OXFORDSHIRE COUNTY COUNCIL'S RESPONSE TO CONSULTATION ON THE FOLLOWING DEVELOPMENT PROPOSAL

Application No: 14/01384/OUT-2

Location: Bicester Eco Town Exemplar Site Banbury Road B4100 Caversfield

Transport

**APPLICATION 1 NORTH OF LORDS LANE - MOVEMENT AND ACCESS**  
 BIMP6 110C NW BICESTER APPLICATION - PARAMETER PLAN

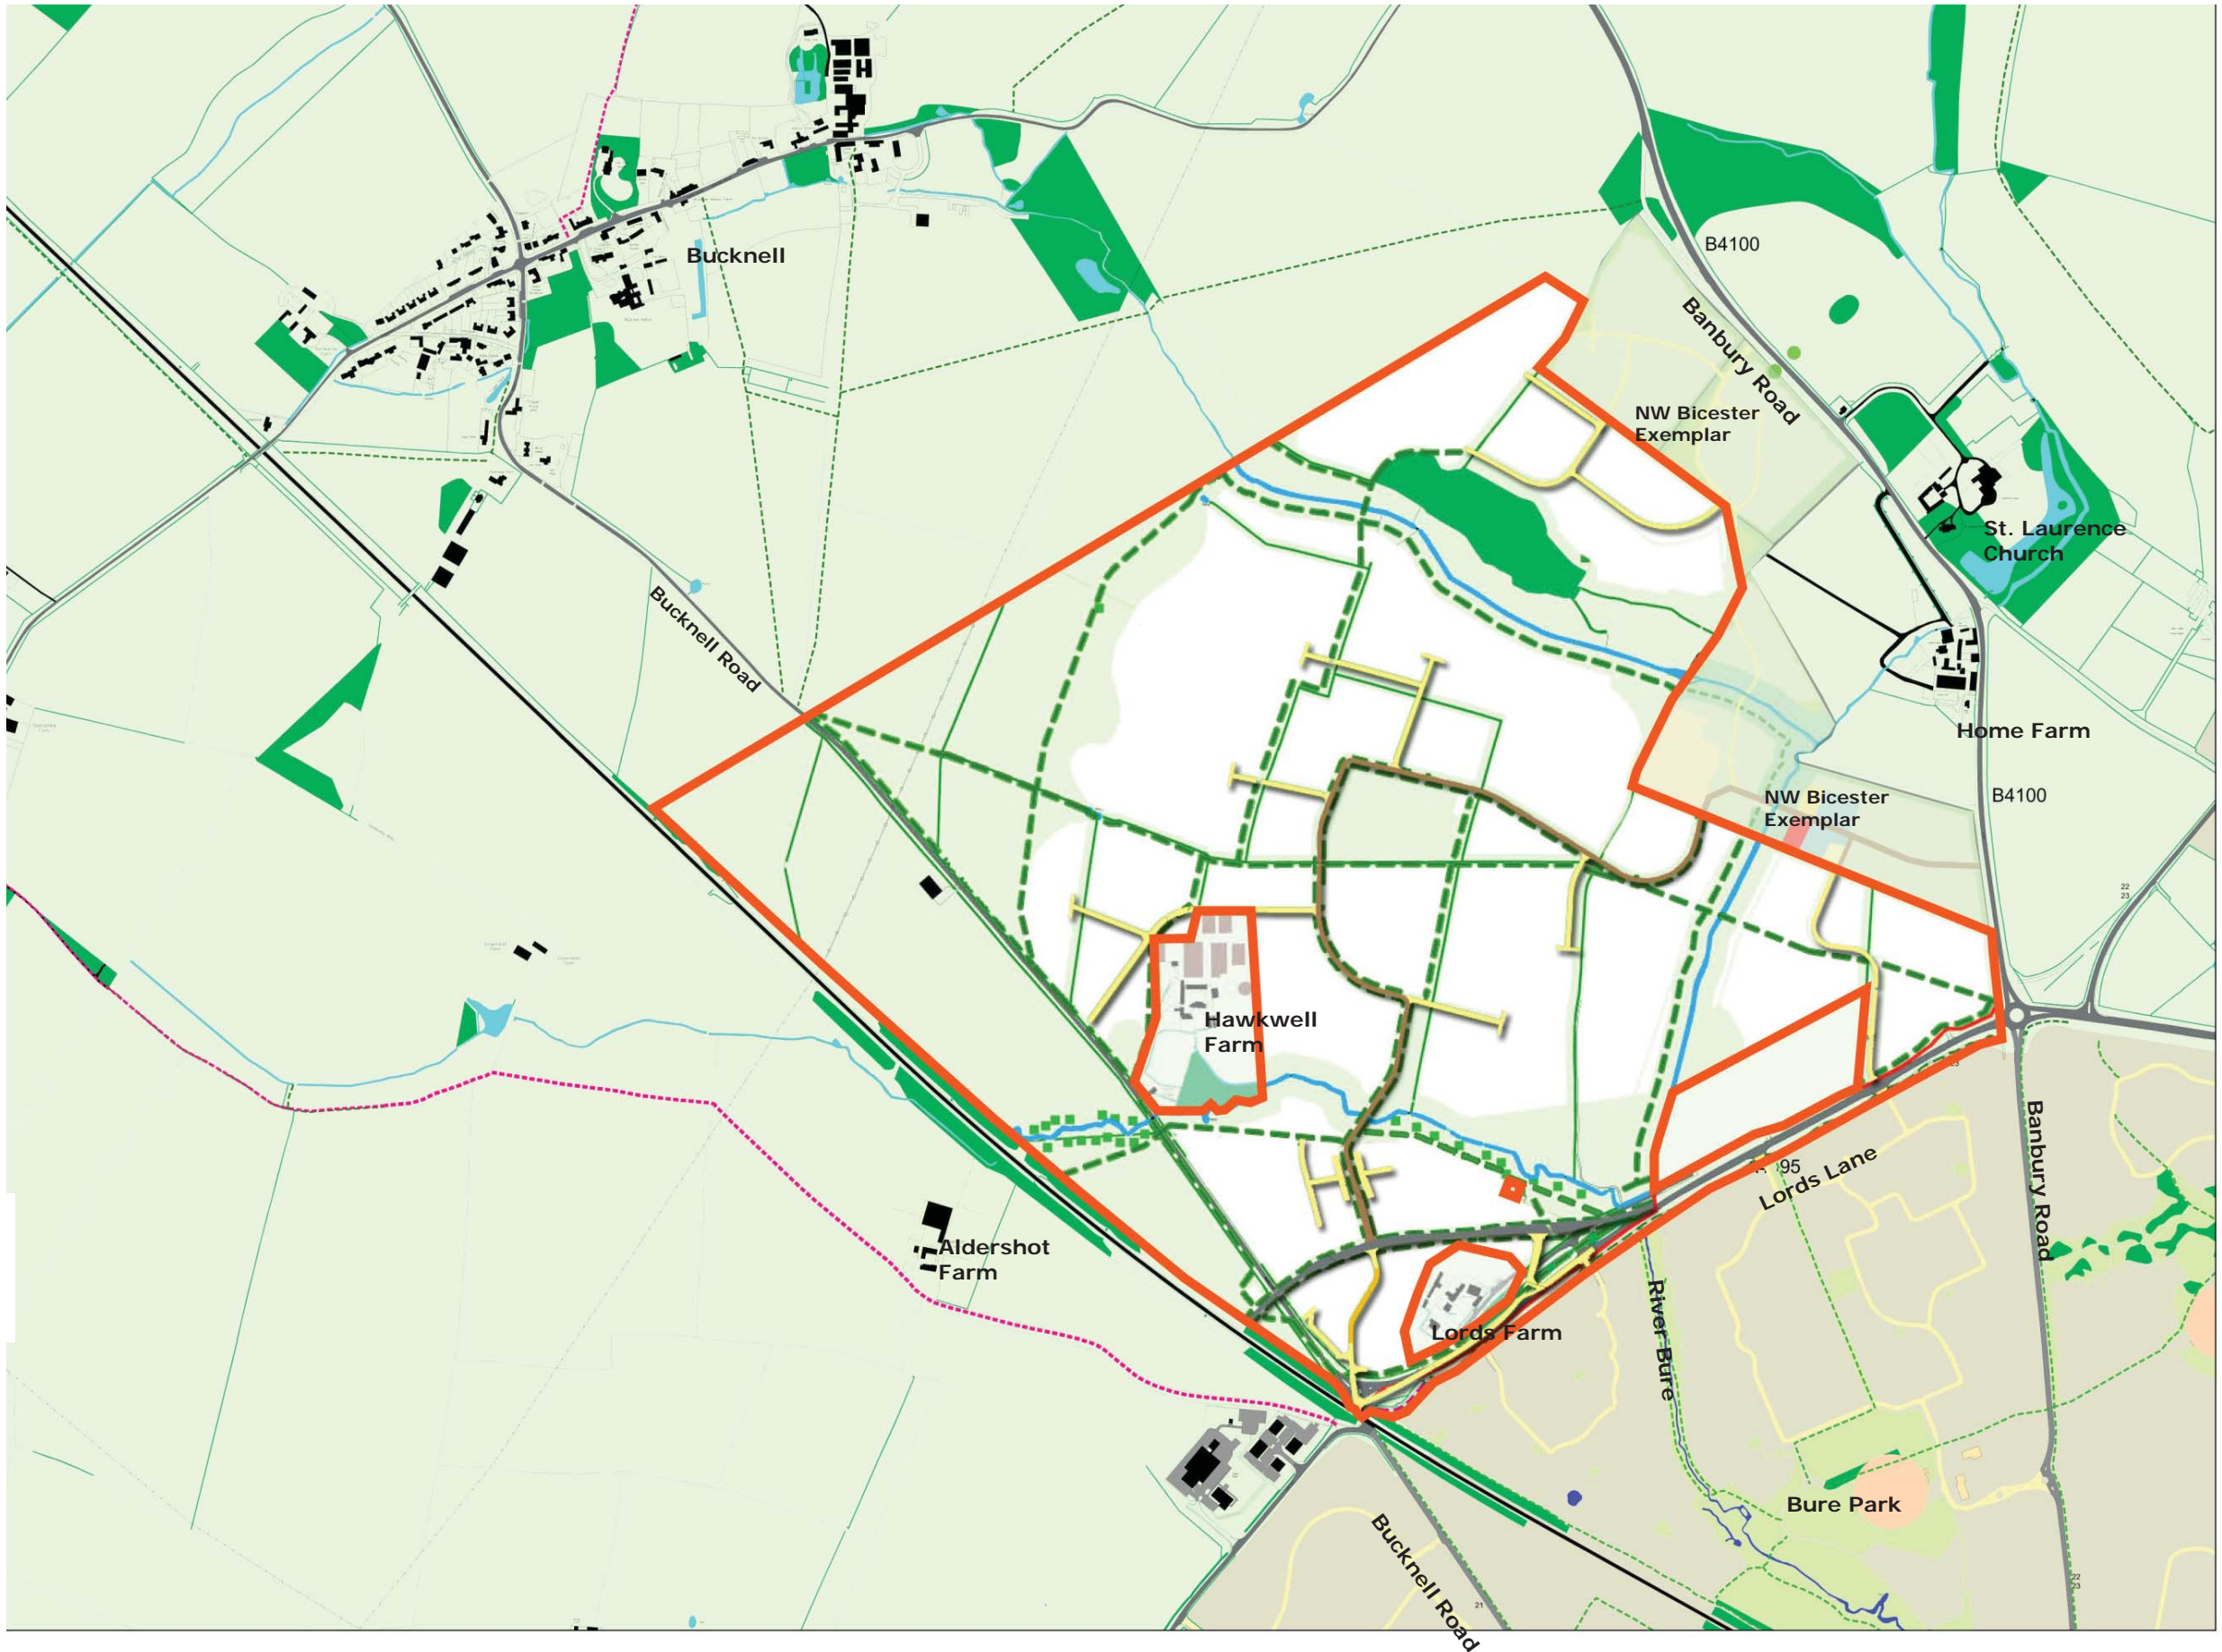
The Movement and Access parameter plan should show positions for the bus stops. At the village centre the stops need to be as close to the junction with the Strategic Link Road as possible: northbound on the NW corner, eastbound on the NE corner, southbound on the SE corner, and westbound on the SW corner. **Further detail required.**

Indicative stops should be shown for other stops in the bus loop, including any required on temporary bus loops. **Further detail required.**

Cycle/pedestrian routes: Additional proposed routes are welcomed. However, the dotted green line on the primary route between the sports pitch and the school playing field appears to have been removed.

Where the cycle link has been moved from the south to the north of the stream, it is difficult to see how this would reconnect with Lords Lane without a new stream crossing. **Further detail is required.**
